Recommendation Report for Planning Permission for Works or Extension to a Dwelling

REF NO: BE/35/20/HH

LOCATION: 392 Chichester Road
Bersted
PO21 5DR

PROPOSAL: Single storey rear extension, first floor side extension.

PROPOSED GROUND FLOOR PLAN

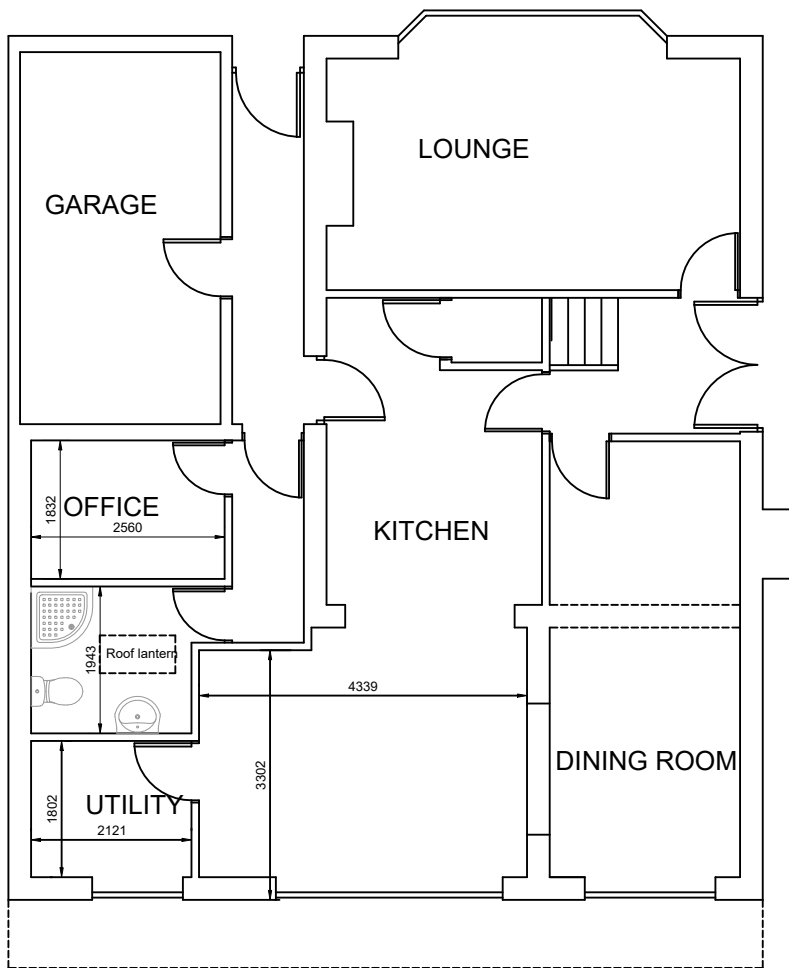
A single storey rear extension will be constructed. There is an existing addition of 3.5m depth however this will be replaced and run along the full rear elevation. The extension will have the same depth at 3.5m however will also have a roof overhang for a further 1m. It will have a flat roof with a height of 2.85m.

With the house detached, an extension of 4m depth could be constructed under permitted development and due to the height and depth proposed which is only slightly larger, with no side windows, it is not considered to result in an adverse overbearing or overshadowing impact upon neighbouring amenity, with 3m retained to the western boundary.

PROPOSED FIRST FLOOR PLAN

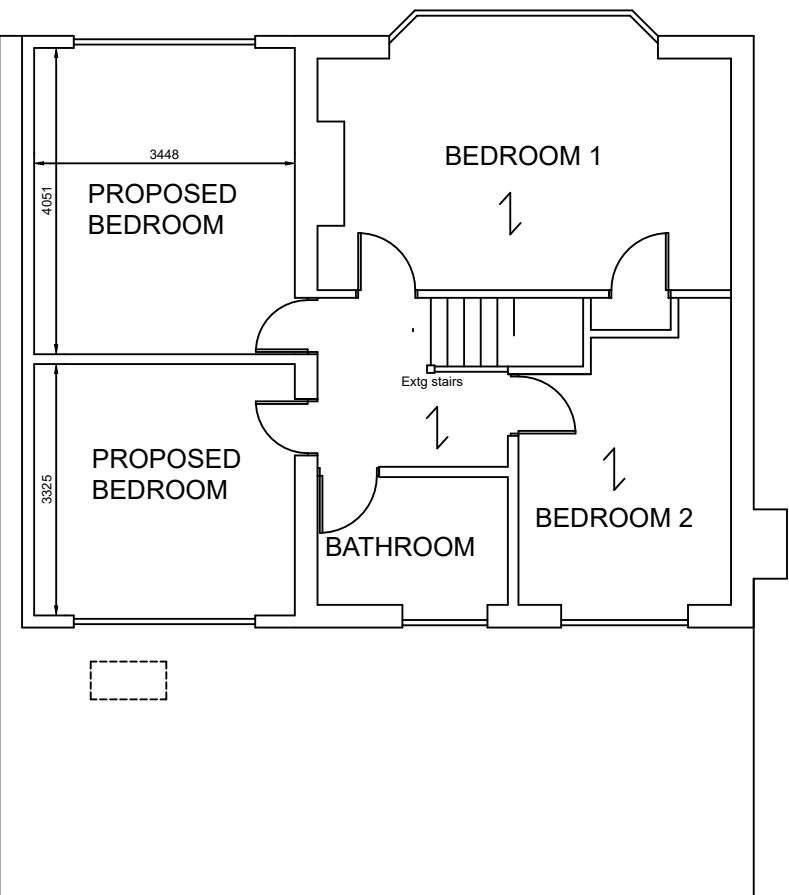
The first floor extension above the garage runs along the eastern side elevation meeting with the existing rear wall. It is slightly stepped in from the ground floor eastern elevation by around 0.35m however with no side windows to the first floor addition and with no side windows to No.390, it is not considered to result in an adverse overlooking impact upon this property.

There will be an additional window to the rear at first floor level, however due to the siting with no views into direct windows, it is not deemed to result in overlooking additional to that which is already achievable. An additional window to the front, will overlook the street scene. With the rear development at single storey, doors to the ground floor will overlook the garden of the host dwelling.

PROPOSED FRONT ELEVATION

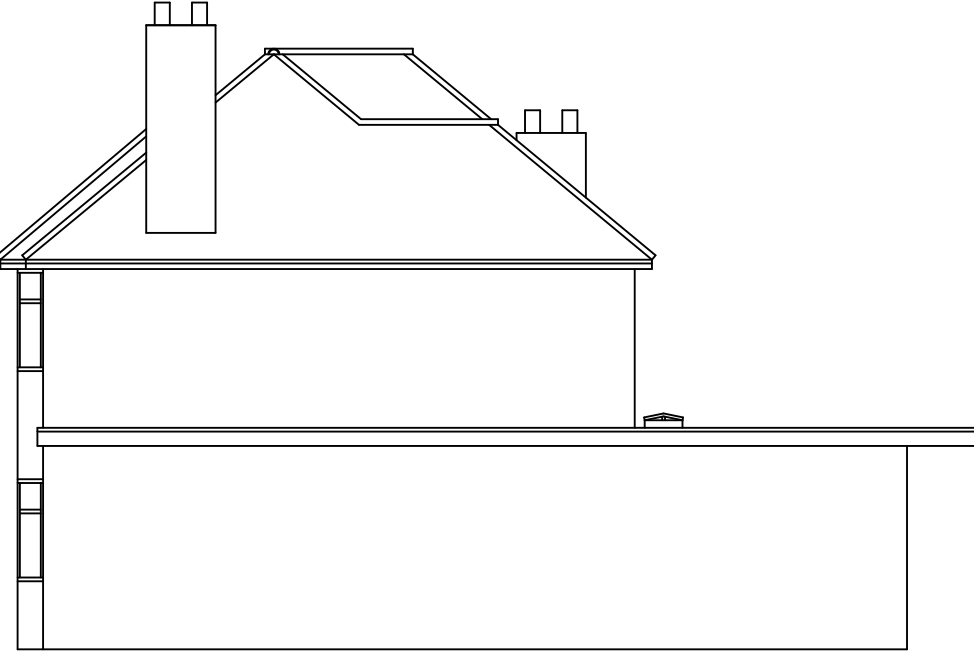
The development is situated to the side and rear of the dwelling and the first floor addition will be highly visible from the street scene.

This is considered a subservient addition and will have a hipped roof which matches in appearance to that of host dwelling. Eaves and ridge height will match which ensures its appears well integrated.
